## DN04234A SPRINT\_BLACK\_FOREST 2746 RUSTIC GROVE COLORADO SPRINGS, CO 80921 SBA SITE ID: CO046107-A CONFIGURATION 56791EZ\_SR\_U21

Project Title:  
**DN04234A  
SPRINT\_BLACK\_FOREST**  
2746 RUSTIC GROVE  
COLORADO SPRINGS, CO 80921

Drawing Number: **T-1**

Drawing Title:
 ENLARGED
 COMPOUND PLAN

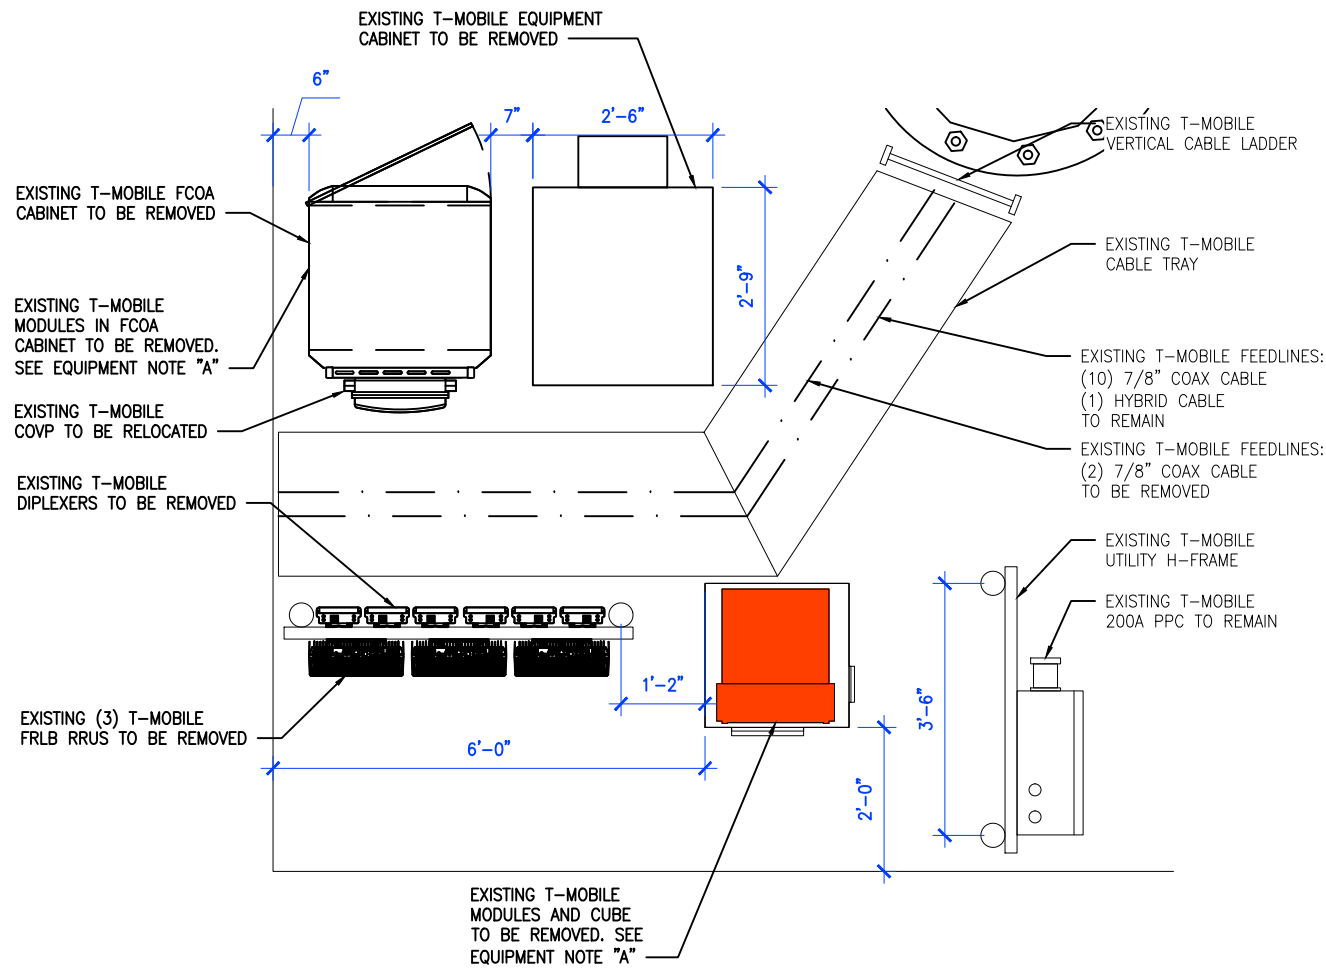
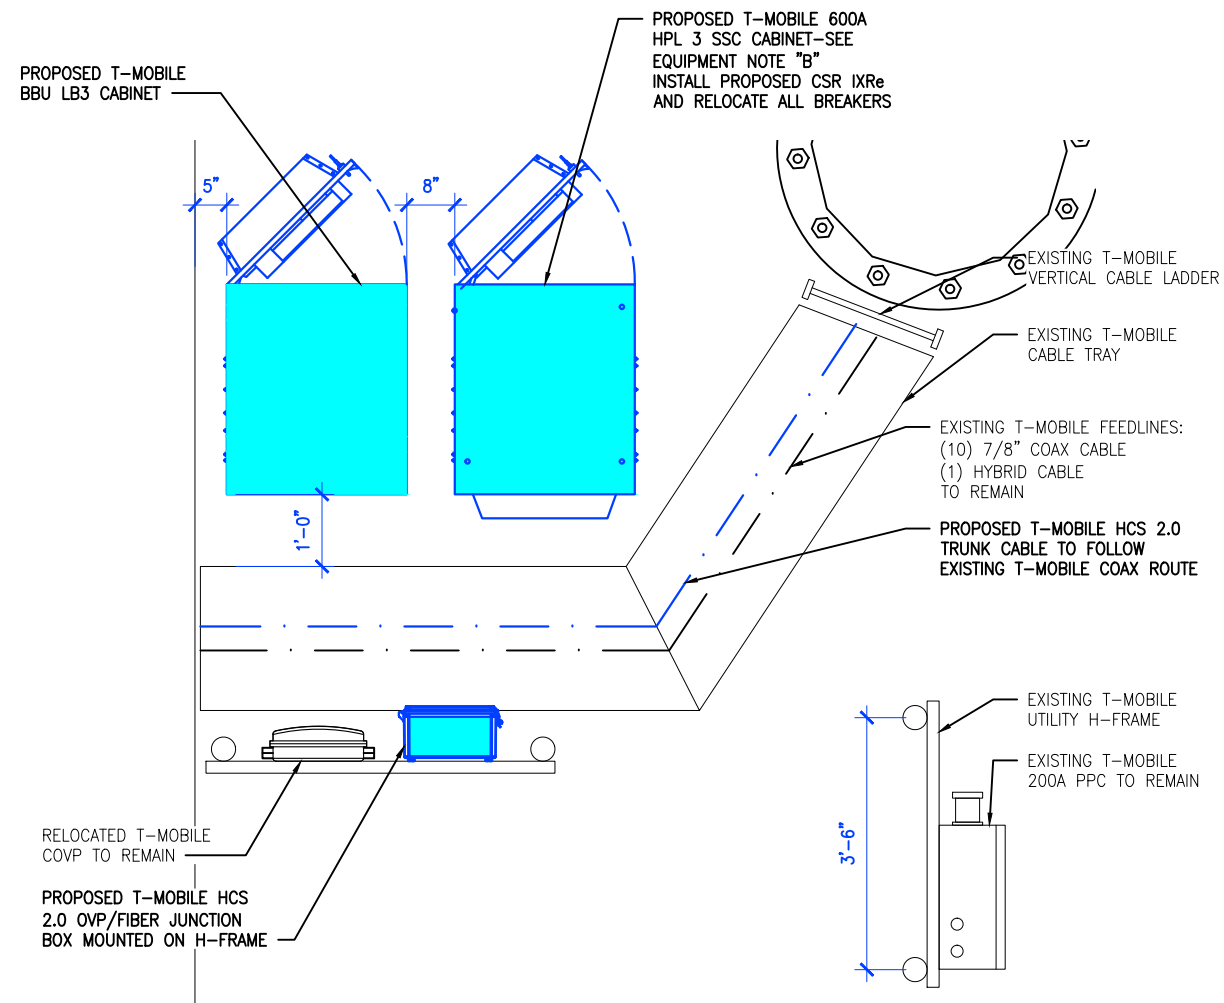
please add the following to the site plan:

- Owner name, contact telephone number, and email for responsible party
- Applicant name (if not owner), contact telephone number, and email for responsible party
- Property tax schedule number
- Legal description
- Lot size
- Current zoning of the property
